Current Zoning: B-1 (neighborhood business)
Proposed Zoning: MUDD-O (mixed use development, optional) with three-year vested rights

Approximately 0.34 acres located at the southwest intersection of Seigle Avenue and Belmont Avenue, north of Harrill Street.

The petition proposes rezone a lot previously used as an auto car garage to allow the construction of a 9,000-square foot mixed-use building residential and nonresidential uses.

SITE PLAN SCALE 1:20

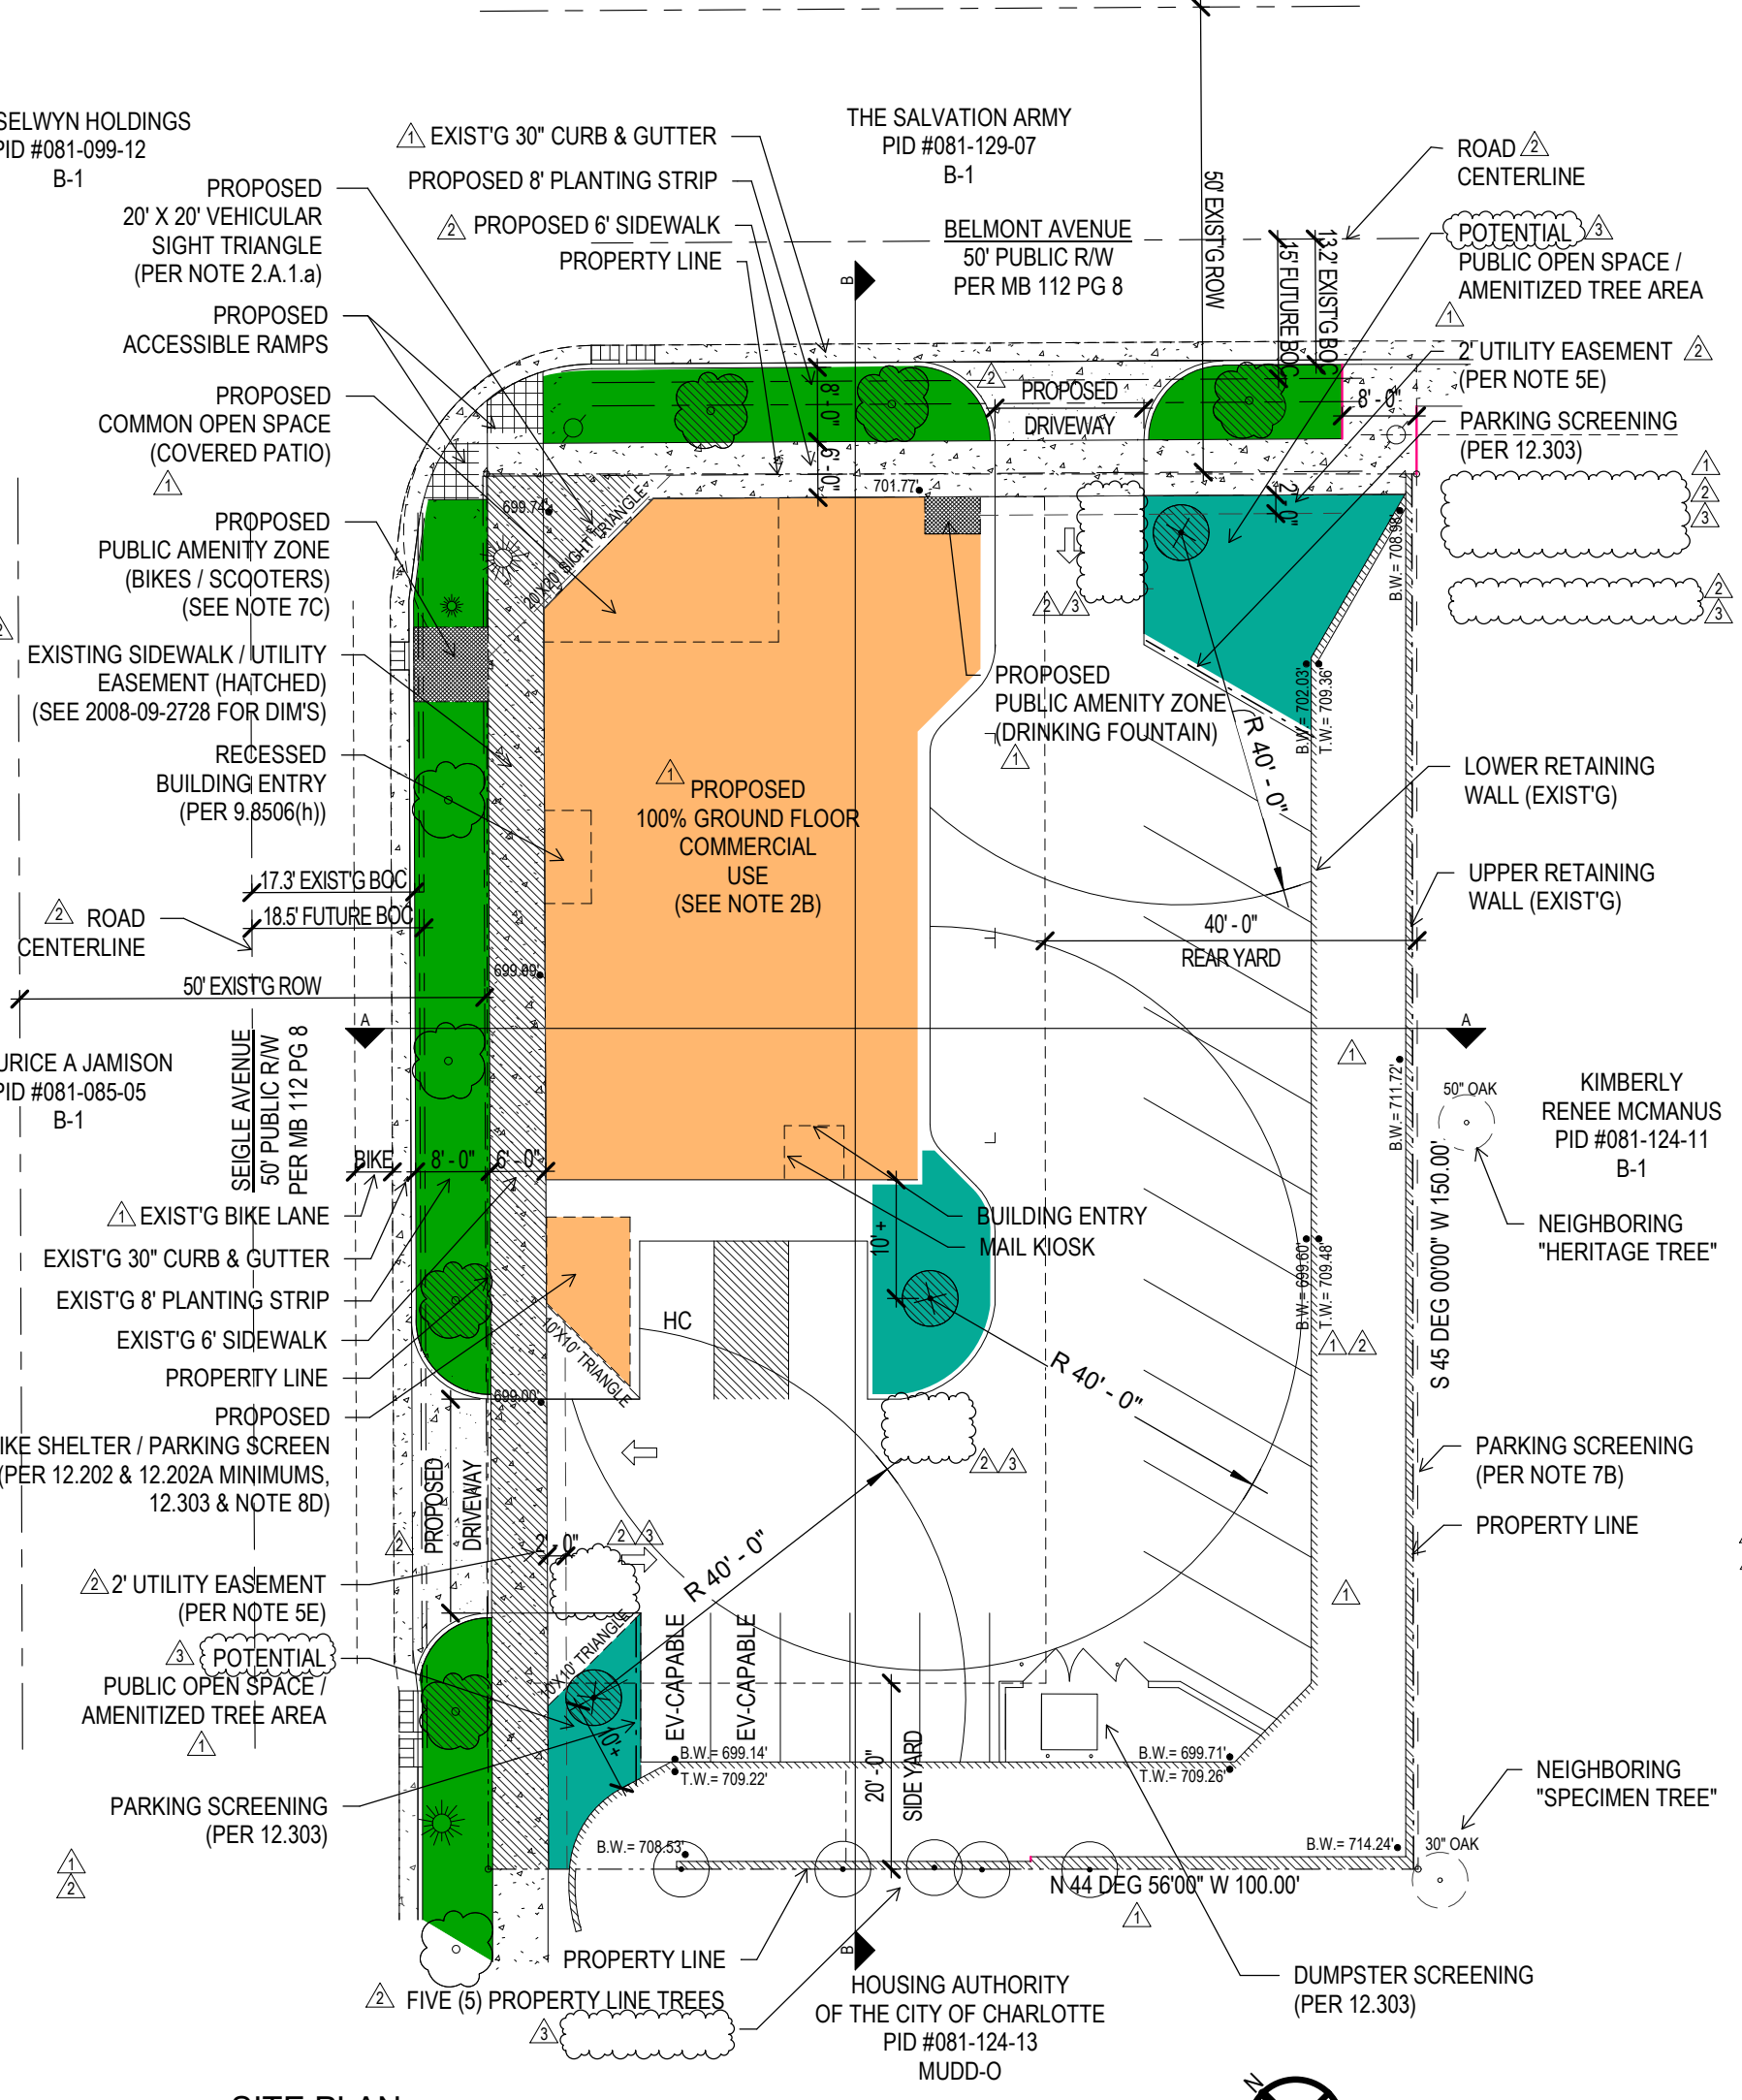
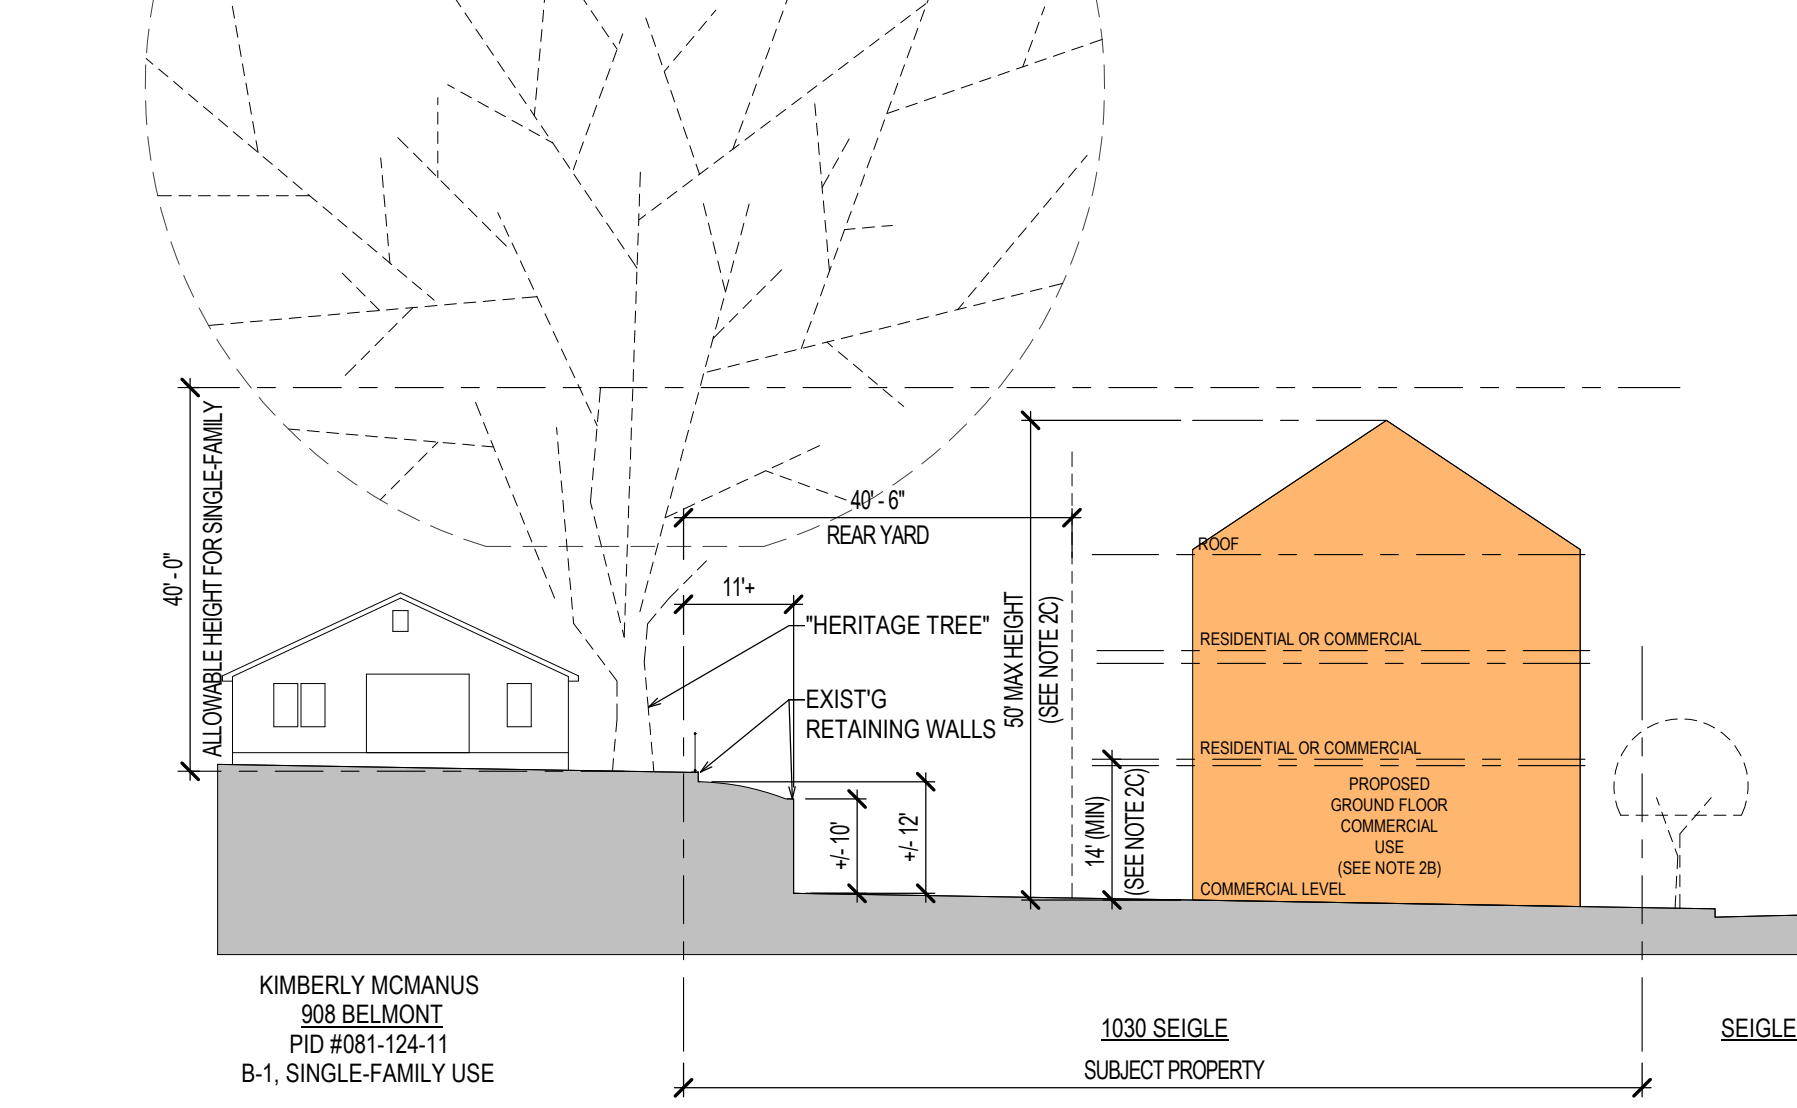
Existing curb and gutter can remain in existing location but label and dimension the future curb and gutter location from the centerline for each road on the site plan. Addressed

- ~~1. The site plan shall label and dimension the right of way from the road centerline. Site plan shows 25' to centerline but does not show the existing 50' from centerline. Label and dimension the existing 50' right of way from centerline of road.~~ Addressed

- ~~5. Petitioner should revise the site plan and conditional notes to show sidewalk utility easement on plans behind proposed sidewalk.~~ Addressed

6. ~~Petitioner should revise the site plan and conditional notes to show 10x10 triangles behind the sidewalk.~~ **Addressed**

7. ~~Review urban tree requirements. While the 10' no build zone can be counted towards tree save there must still be a minimum of 10' of replanted tree save. (20' total width) Trees cannot be planted within 10' of a structure/retaining wall. Utilities such as transformers are not permitted within trees save or amenitized tree save.~~ **Petitioner response:** Petitioner has reconfigured preliminary off-street parking layout to accommodate 10' distance & 10' width requirements. Potential transformer locations have been moved outside of amenitized tree save (See Site Plan on RZP-01, Rev 2). **Update:** Per discussion, the best option for tree save at this point will be provided per the ordinance and removed "potential tree save" designation for areas that we not sure would even qualify as tree save and review that during development plan review. **Addressed**

8. ~~Trees outside of the property line cannot count towards any requirements. Trees must be completely on the property to count towards requirements.~~ **Petitioner Response:** Petitioner commits to protecting the five "property line trees" on southern property line. (See Note 2D, RZP-01 Site Plan, Rev 2). Petitioner is open to amending the wording of this Optional Provision to suit Urban Forestry, if desired. Note: as provided to Henry Kunzig via 4-17-23 email, center measurement of 12" oak is completely on property at dbh. Updated Tree Survey uploaded to ACCELA. Petitioner is willing to reduce protection to just that tree, if desired. **Update:** While trees on the property line can be protected, trees not completely located on the property cannot be counted towards meeting tree save requirements. **Addressed**
